Recommendation Report for Planning Permission for Works or Extension to a Dwelling

REF NO: LU/333/21/HH

LOCATION: 2 Larkspur Close
Littlehampton
BN17 6WB

PROPOSAL: Two storey side extension, single storey rear extension and part conversion of garage to habitable use.

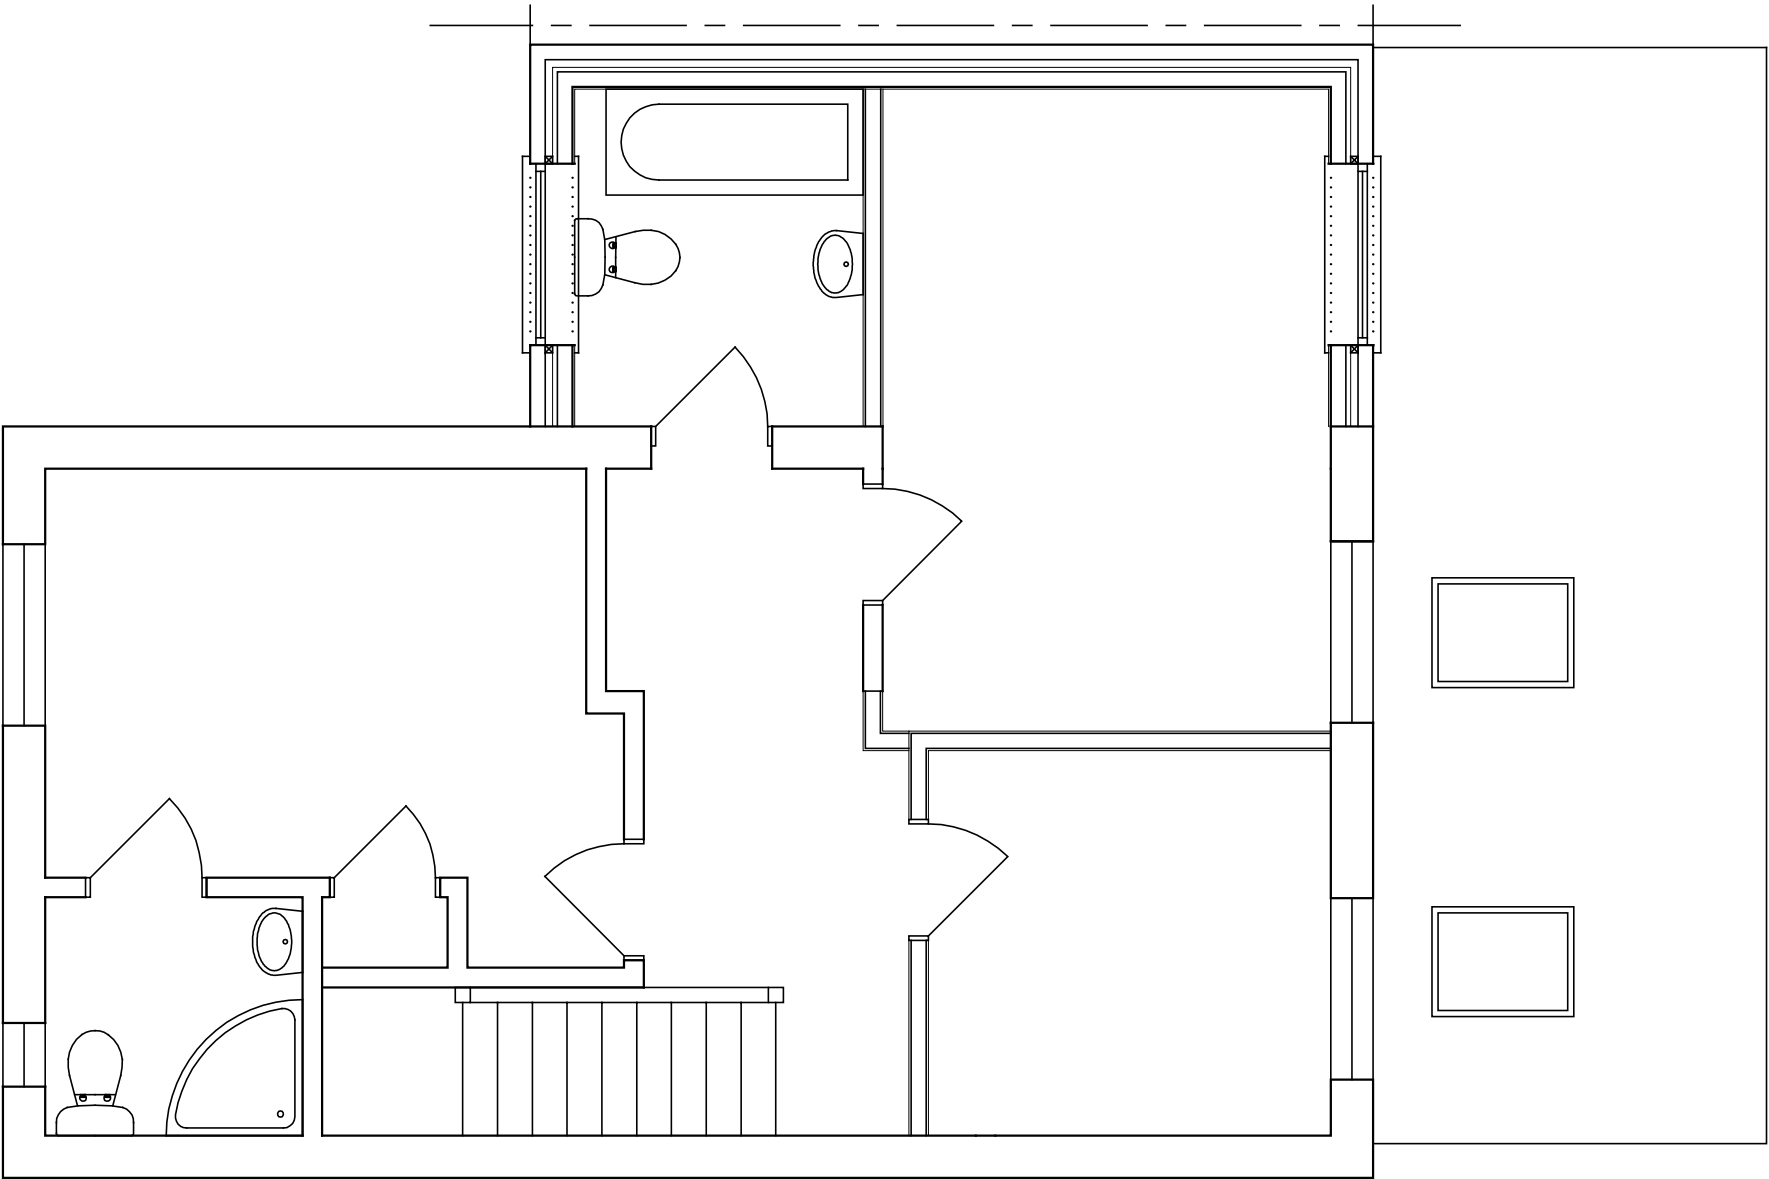
The proposed extension is not considered to give rise to any significantly adverse impact on the neighbouring dwellings. The orientation of the extension is considered to be suitably positioned in order to prevent any unacceptable overbearing or overshadowing of adjacent dwellings. The 45-degree rule for rear extensions will be adhered to and the first floor extension will not go beyond the existing rear building line.

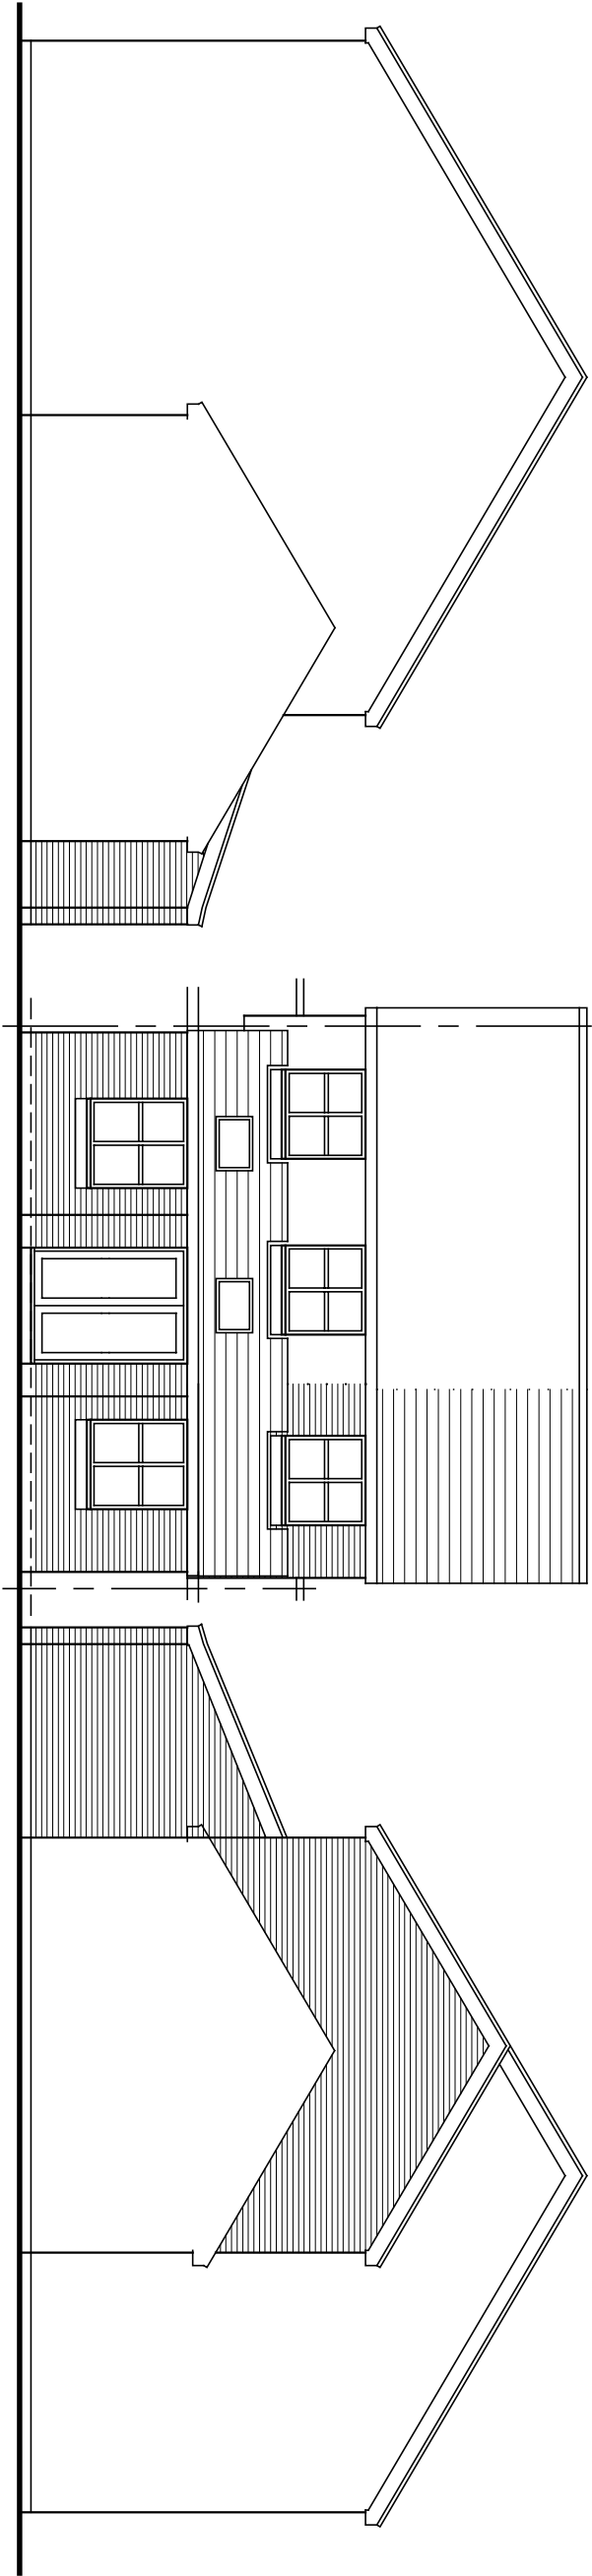
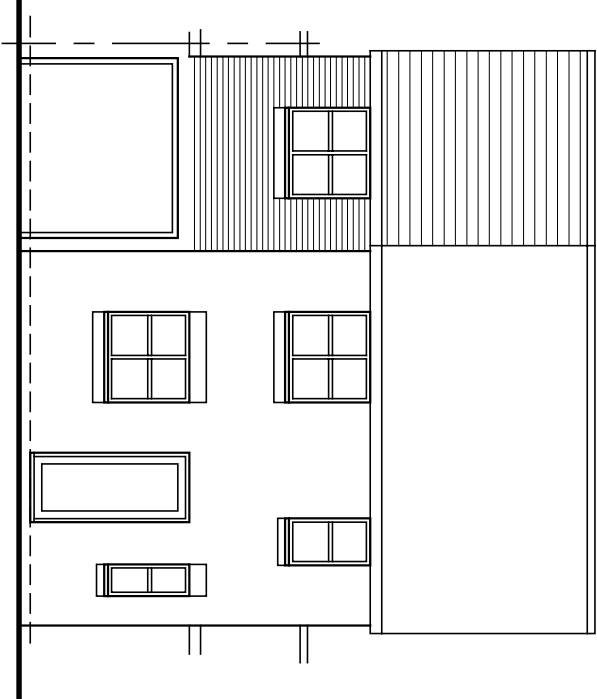
The extension is subservient to the dwelling in that it will have a lower ridge height and will be set back from the primary elevation. It is not considered to have a significantly detrimental impact on the established character of the host dwelling as a result of its design, scale and use of materials. It would be visually integrated with the existing dwelling and would result in a sympathetic addition to the property.

The impact of overlooking from the rear is no worse than that resulting from the existing dwelling, and there are no windows proposed on the side (South-eastern) elevation of the extension, this is also considered to preserve the existing level of privacy.

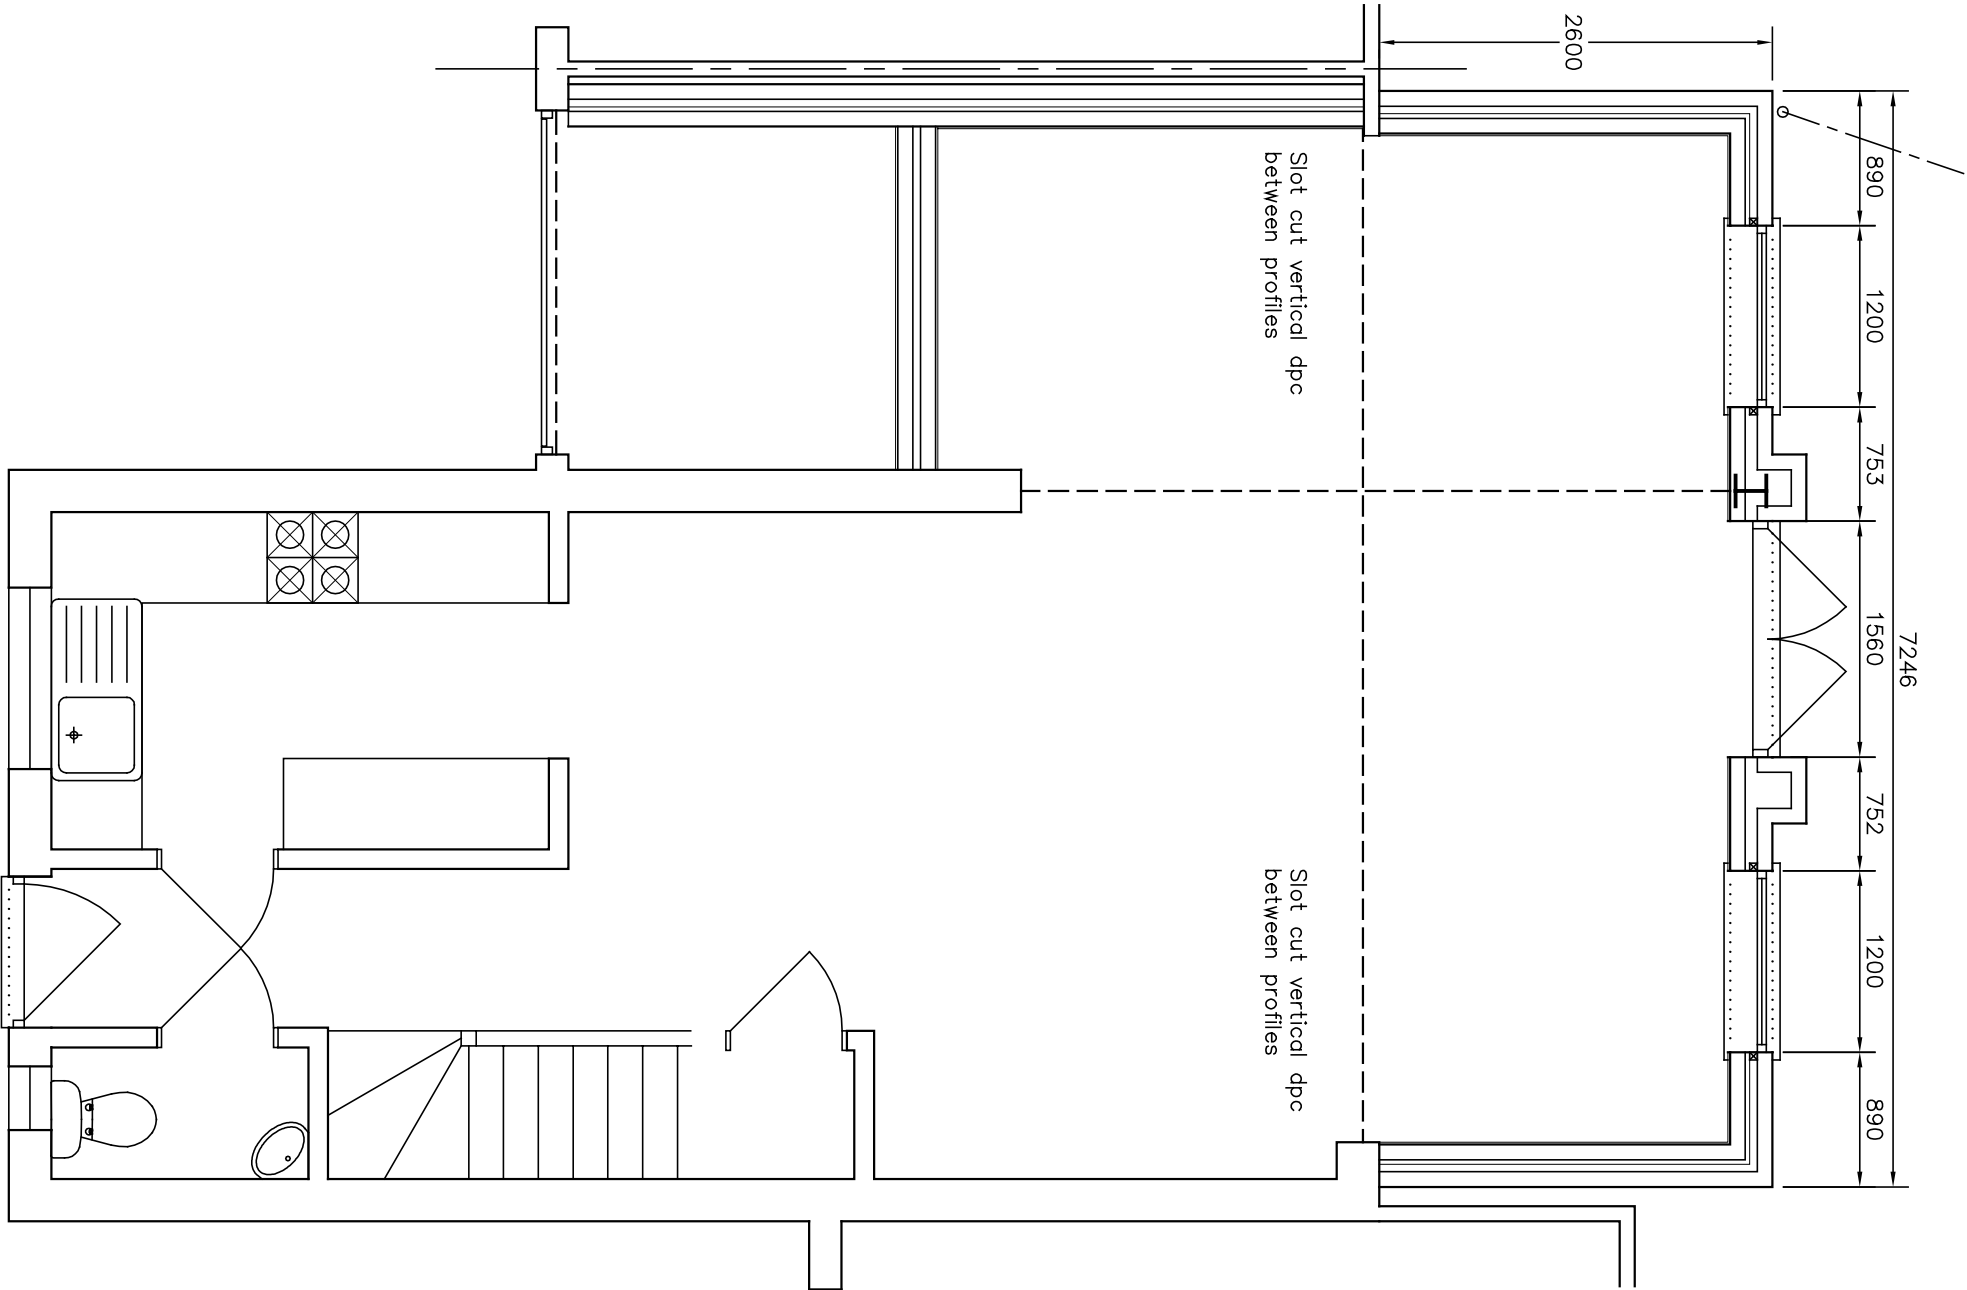
Parking has been raised as a concern for neighbours, whilst the property will only be afforded 1 parking space further to the works proceeding, it is noted that there is ample unrestricted on-street parking. As there are no restrictions to the conversion of the garage in to habitable accommodation the property could convert the garage without the need to seek planning permission.

The conversion of the garage is considered acceptable, and without parking restrictions on site the amount of parking provision is in accordance with policy T SP1 of the Arun Local Plan.
